The Planning Inspectorate
[via Planning Inspectorate website]

Our ref: NA/2024/116840/05-L01
Your ref: H2Teesside
Date: 13 January 2025

**H2TEESSIDE PROJECT – ENVIRONMENT AGENCY COMMENTS ON DEADLINE
5 SUBMISSIONS
LAND EITHER SIDE OF THE RIVER TEES WITHIN THE BOROUGH OF
REDCAR AND CLEVELAND AND STOCKTON-ON-TEES ON TEESSIDE AND
THE BOROUGH OF HARTLEPOOL IN COUNTY DURHAM**

FIGURE TITLE
H2Teesside DCO Application Pipeline Statement

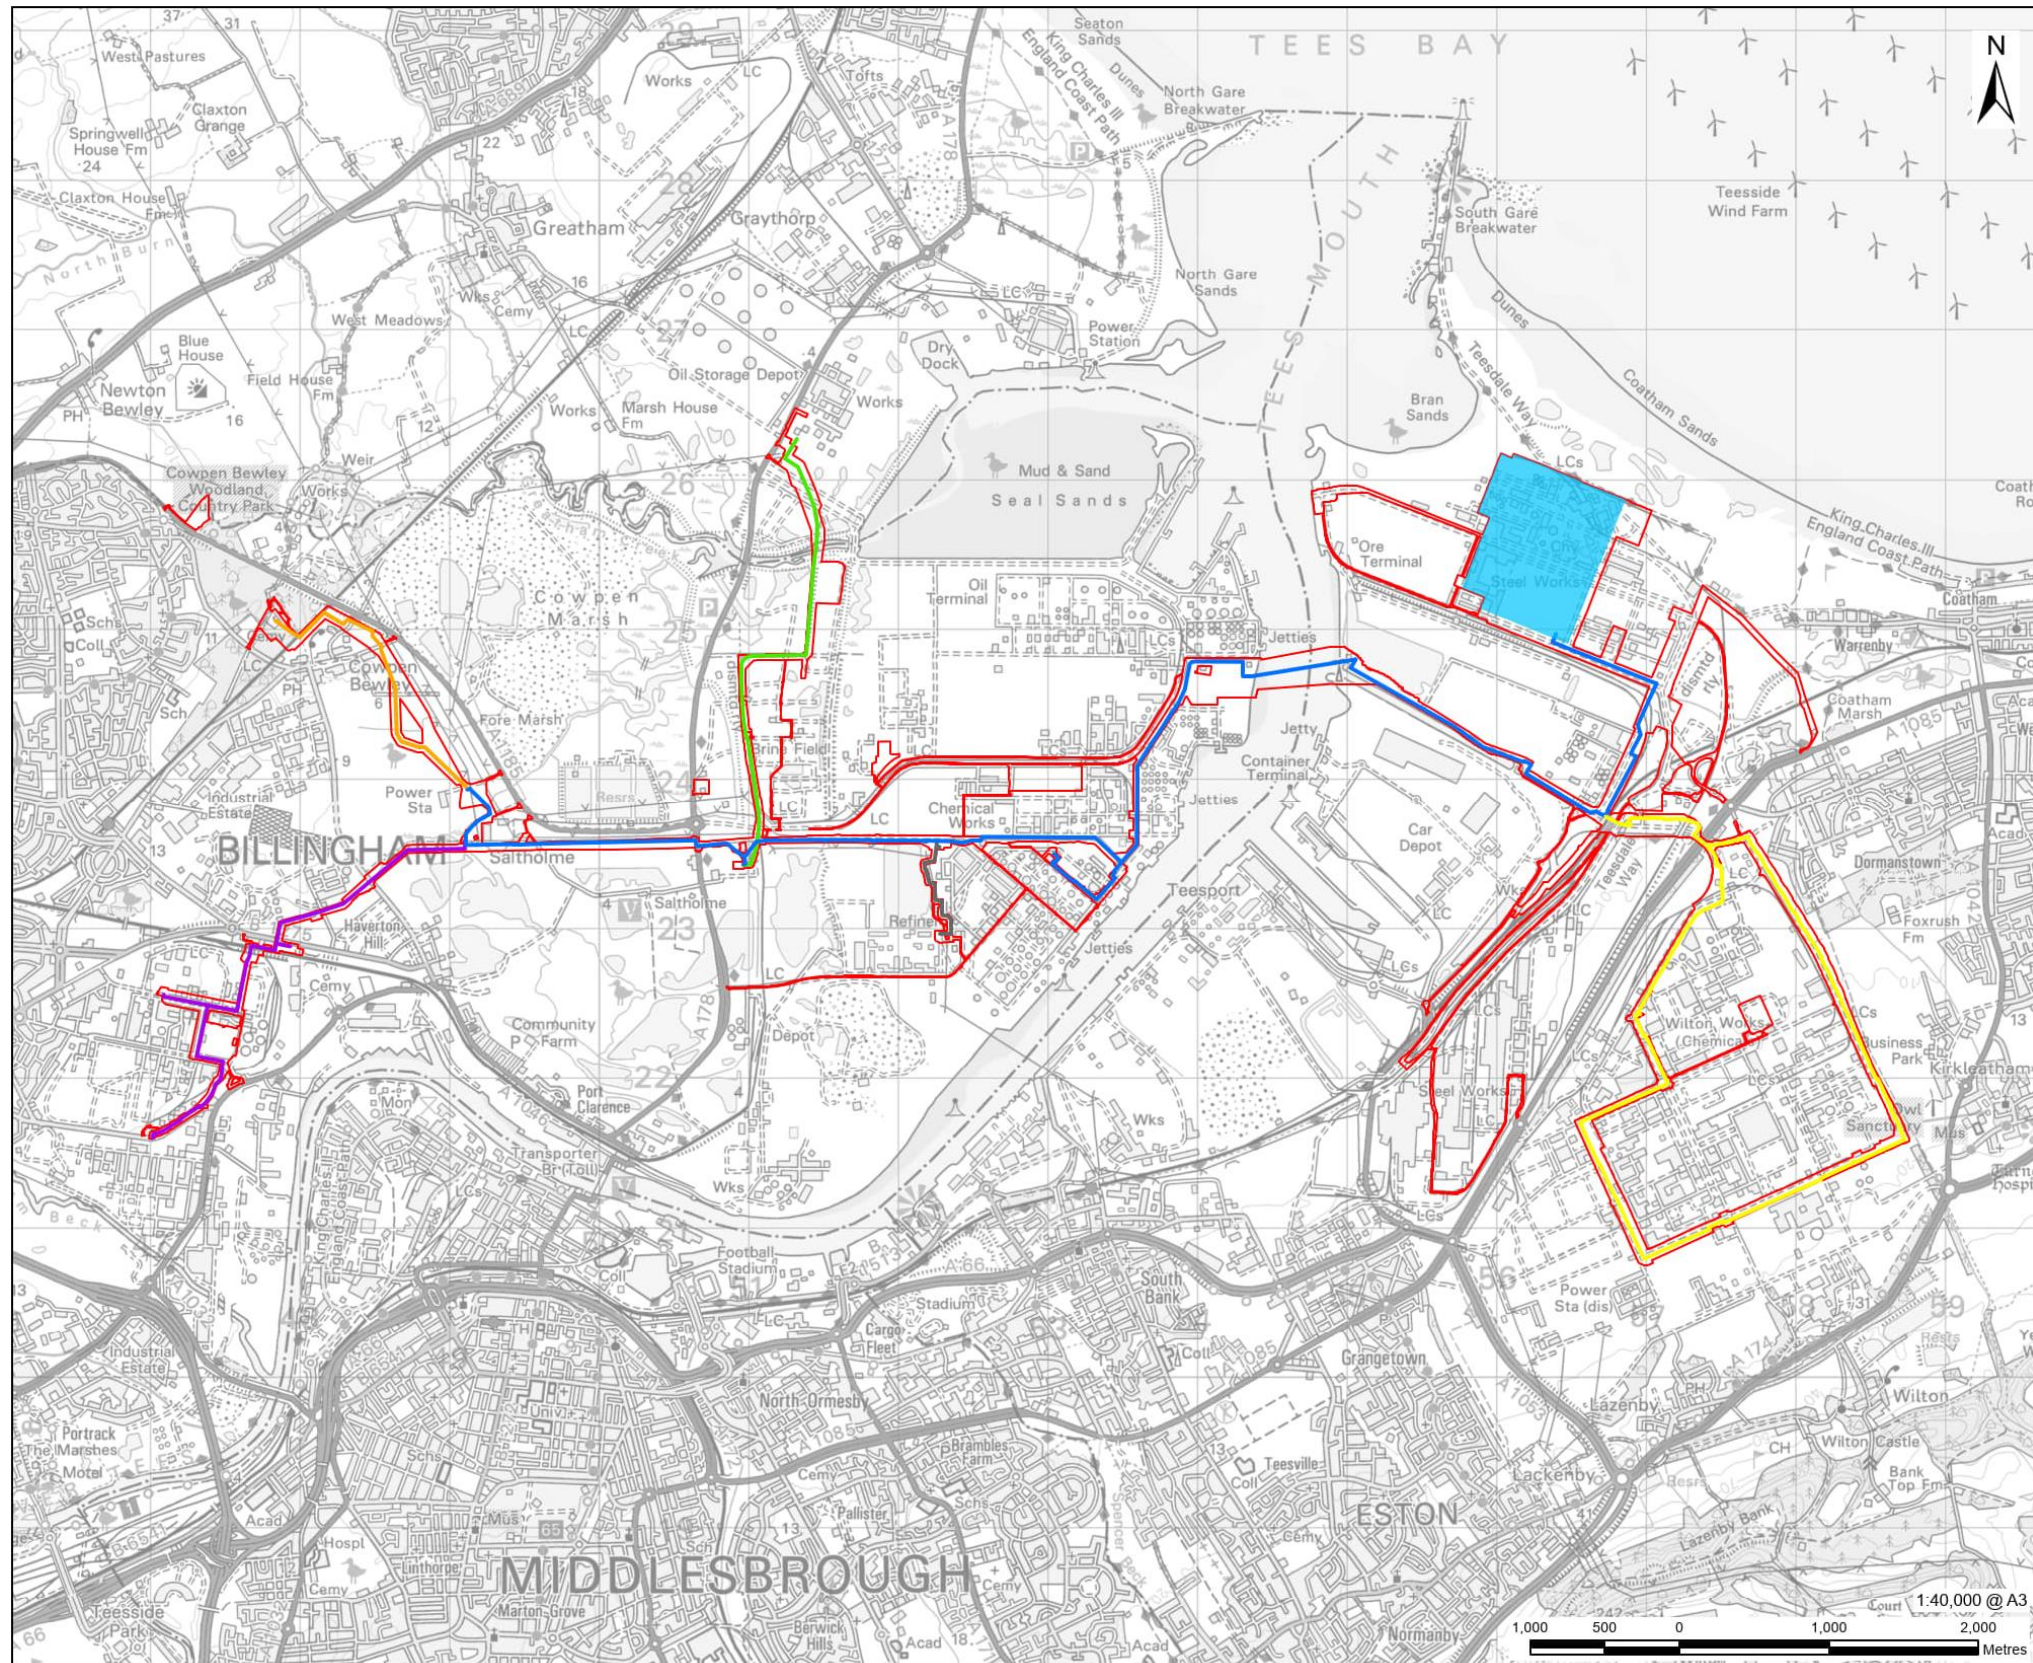
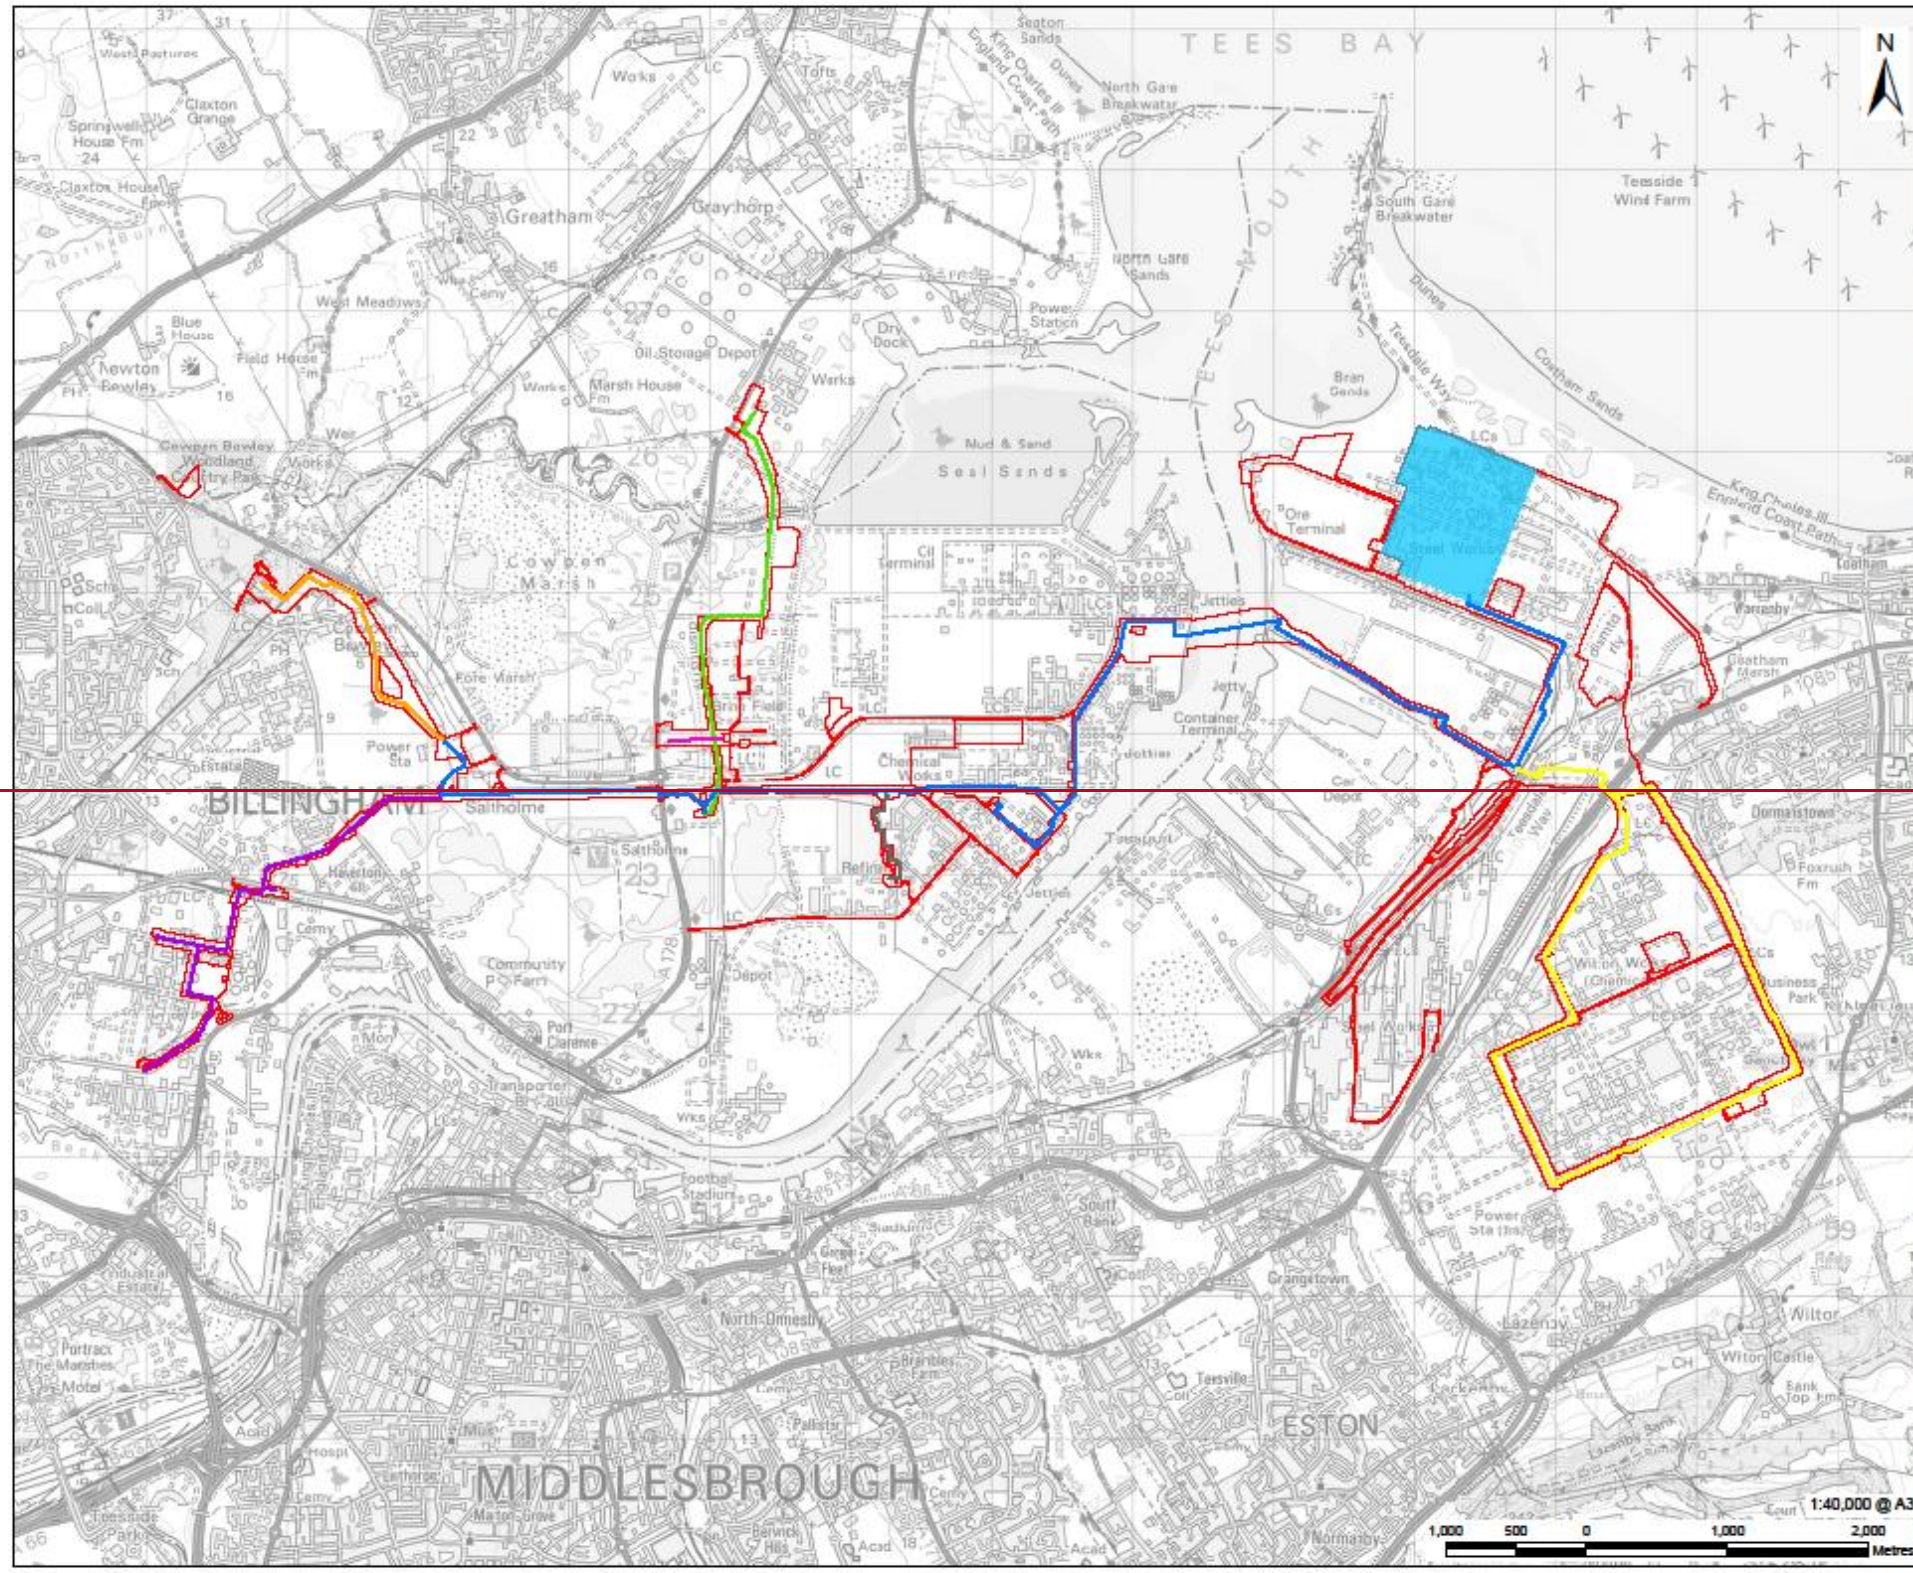
REF.NO.	EA Comments
Q2.15.2	<p>The applicant has included more detail within document <u>EN070009-001329-H2T DCO 5.5 Pipelines Statement Tracked Rev 1 16 Oct 24.pdf</u> on the type of pipeline being utilised across the site. This has provided more clarity on which sections of pipeline will be</p>

above and below ground and which pipeline which will use new or existing infrastructure. The applicant has also included an updated visual map for clarity. This will help us to assess associated risk in pursuant of protected provisions.
Q2.15.3	We have assessed the updated Flood Risk Assessment (FRA) submitted with Deadline 5 documents. The applicant has taken our considerations into account regarding storage and compound sites. We expect to see further detail for temporary storage areas and associated mitigation as part of protected provisions and requirement 11.
